Re: CDS22003138 pre-connection enquiry - Subject to contract | Contract denied Connection for Multi/Mixed Use Development of 347 units at 326-328, South Circular Road, Dublin

Irish Water has reviewed your pre-connection enquiry in relation to a Water & Wastewater connection at 326-328, South Circular Road, Dublin (the **Premises**). Based upon the details you have provided with your pre-connection enquiry and on our desk top analysis of the capacity currently available in the Irish Water network(s) as assessed by Irish Water, we wish to advise you that your proposed connection to the Irish Water network(s) can be facilitated at this moment in time.

DRAWING TITLE
PROPOSED BASEMENT DRAINAGE DETAILS SHEET 2 OF 2

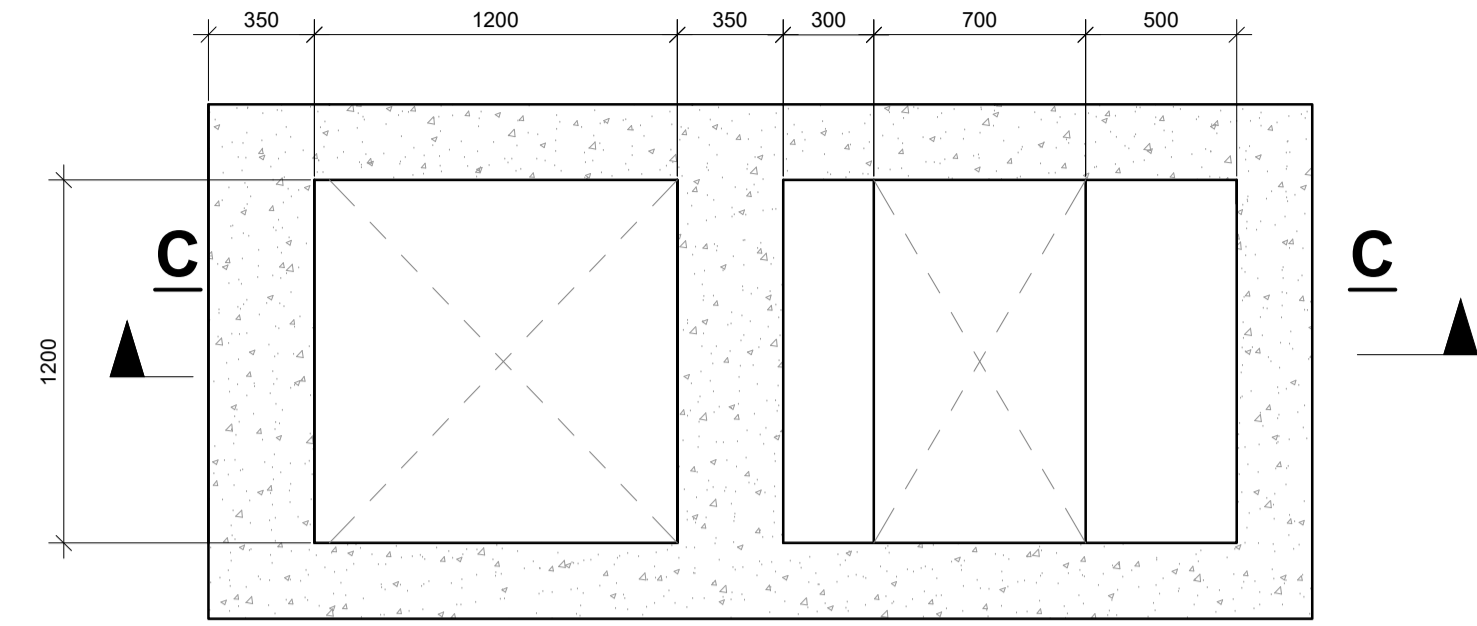
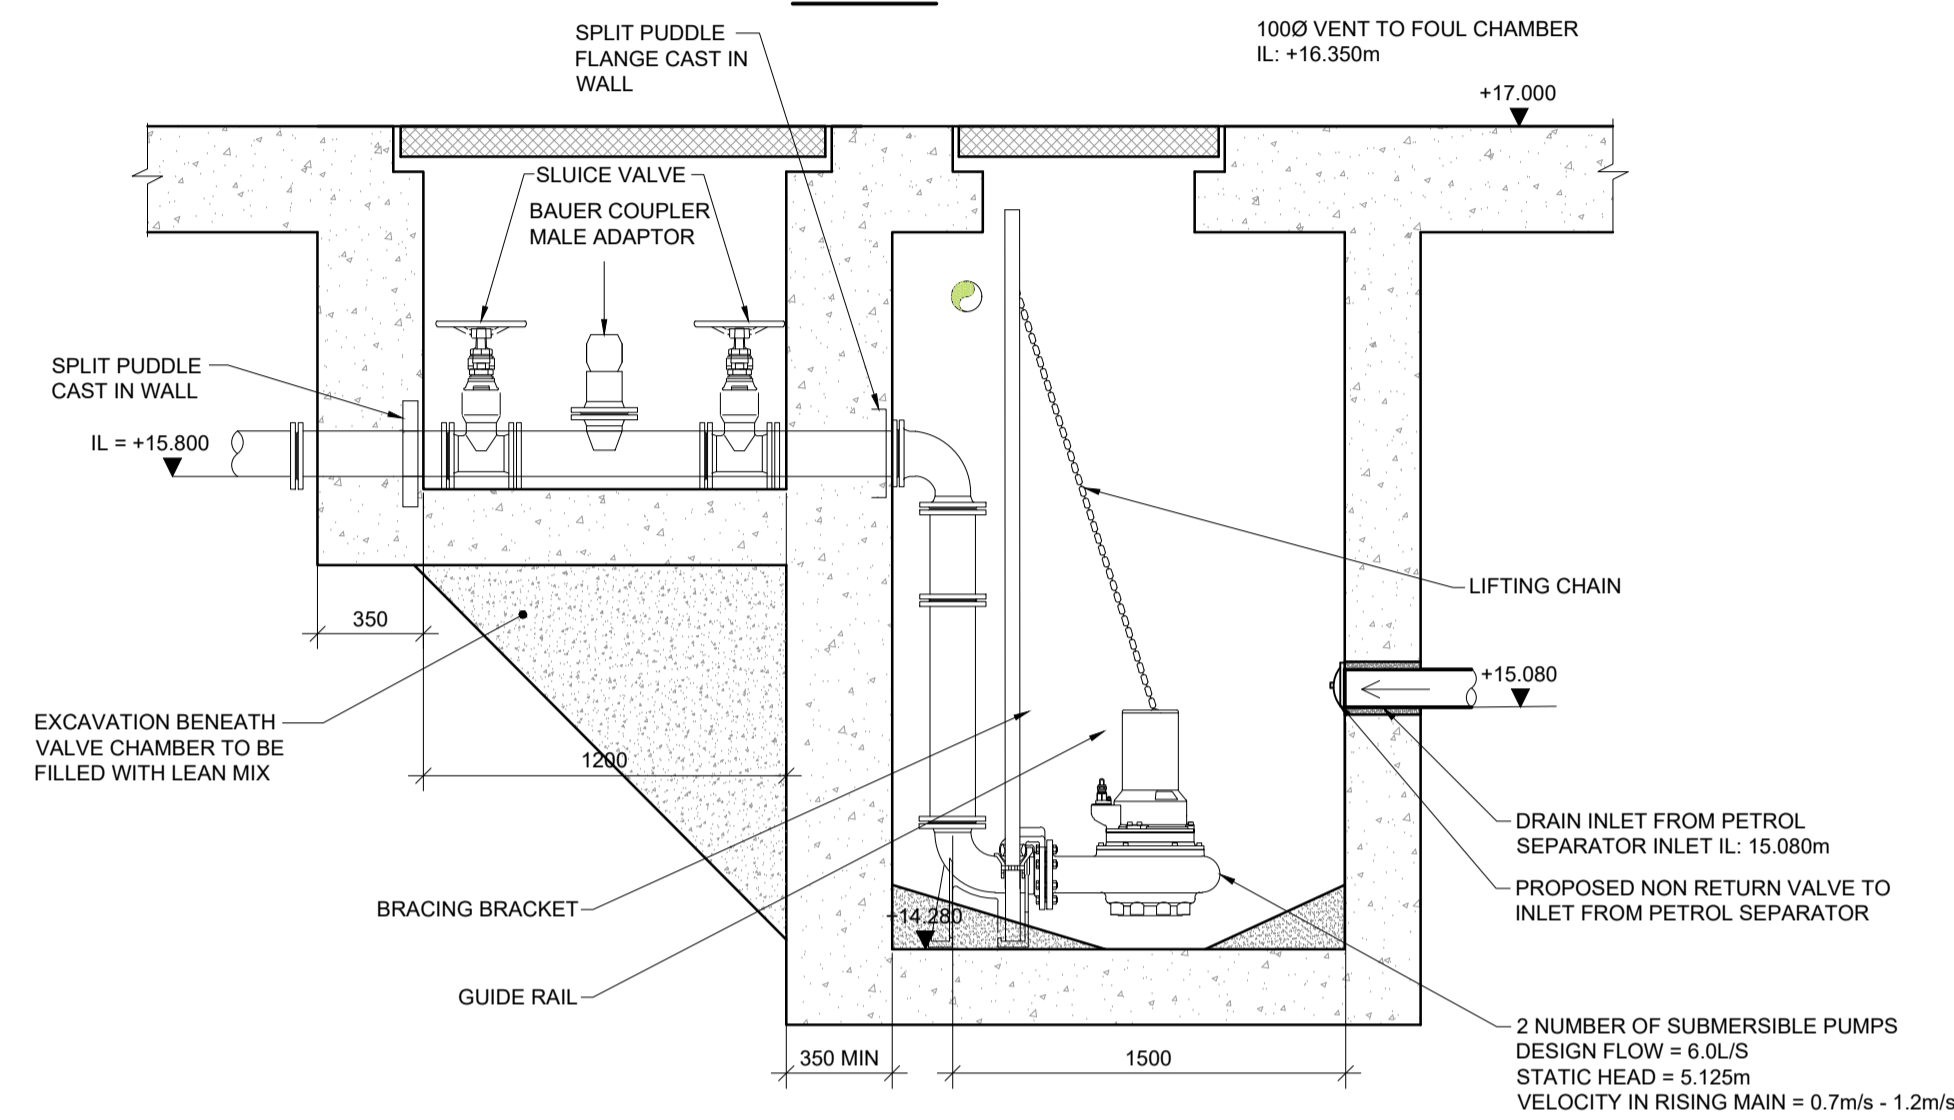
Proposed basement car park should be designed such that surface water from the site and/or surrounding areas cannot flow down to the car park. Wastewater from the car park (contaminated water generated from run off from cars/tyres) must be pumped to ground level to discharge by gravity to the Irish Water Network via a petrol interceptor.
